Application for removal or variation of a condition following grant of
planning permission. Town and Country Planning Act 1990.
Planning (Listed Buildings and Conservation Areas) Act 1990

Erection of extension to existing shopping centre to provide new 9 screen cinema and restaurants at Gallery level including new personnel entrance on New Street level, alterations to existing parking and associated alterations at Retail Mall levels.

dwg no. rev
13160(5)112

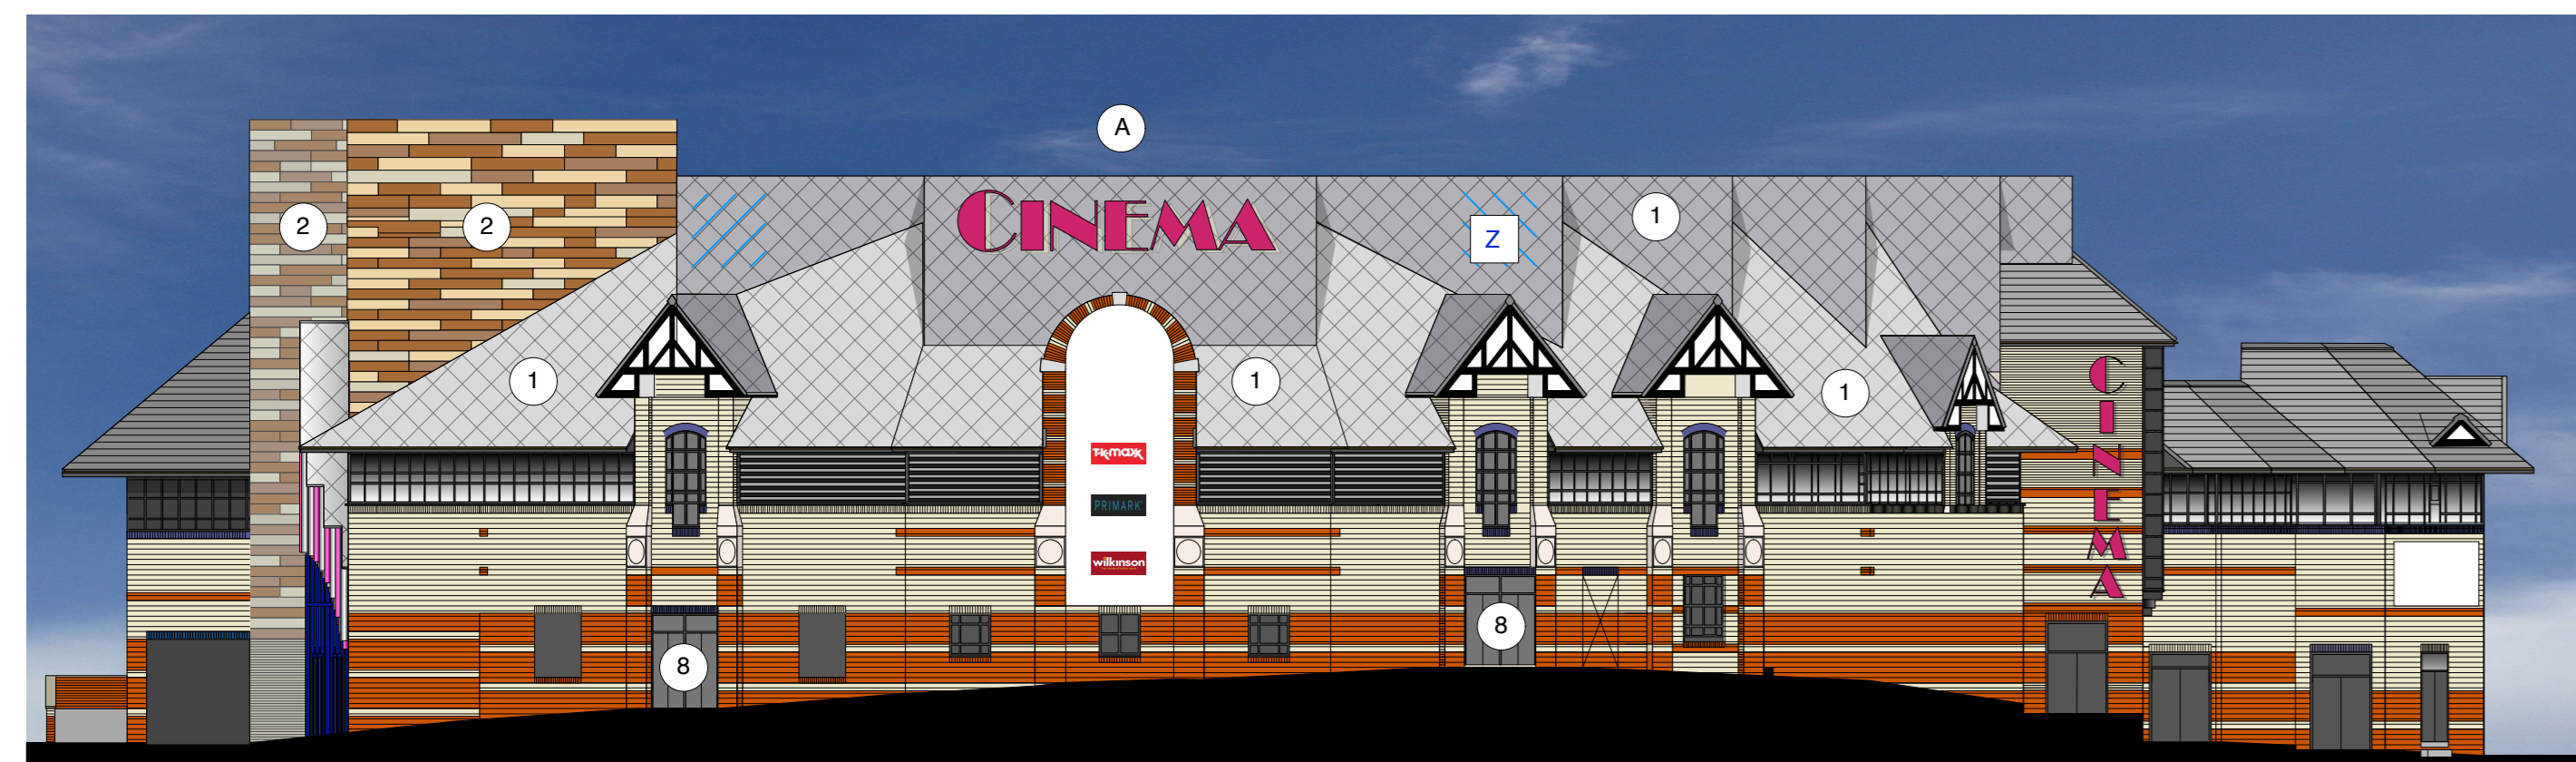
The original Planning Application was designed as a bespoke Cinema for an operator who has subsequently been unable to progress with the proposals. The amended Application is to address changes to suit a new operator who is progressing with the project. The new Cinema operator would prefer to have more smaller seat cinemas to reflect the way Cinema use is changing hence the increase from 9-10 screens with effectively no change to overall occupant numbers. Cinema technology has developed since the original submission and this will now be a fully digital cinema without conventional projection rooms. This results in some minor dimensional changes to auditoria. The changes arise primarily from the change of Cinema operator and design development, the footprint and parking associated with the scheme are unaffected.

Add drawing numbers
13160(5)109 Gallery level as Proposed 13160(5)110 Mezzanine level as Proposed 13160(5)111 Roof level as Proposed 13160(5)112 Elevations as Proposed 13160(5)113 Sections as Proposed 1 13160(5)114 Sections as Proposed 2
